**Subject:** FW: URGENT Kirklands Chipping Boundary Discrepancy 3/2015/0276

Afternoon John,  
the plan looks OK but having studied it more closely there are a couple of issues arising

Client:	KEEPMOAT		
Job:	KIRKLANDS, CHIPPING		
Drawing title:	SITE LAYOUT		
Drawing Number: (Job number)	M3792	100	Revision: C
Scale:	1:100@A1		
Date:	FEB 15		
Drawn by/ checked by:	MCS

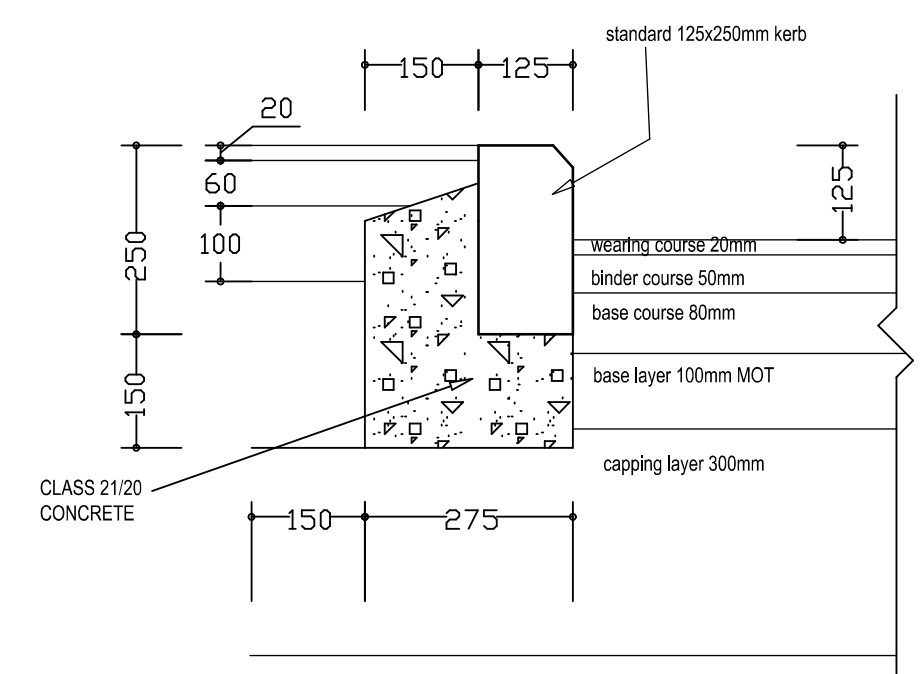
- 1) The use of a tactile paving in the footway to the rear of the building is unnecessary. There is no defined destination in the car park and it could be disorientating to visually impaired people.
- 2) The driver's door of the disabled bay ( assuming entry into the space in forward gear) opens into the landscaped area marked 'C' on the plan. In order to avoid this drivers will inevitably park on the hatched area which would reduce the reversing distance for the cars parked in the adjacent spaces.
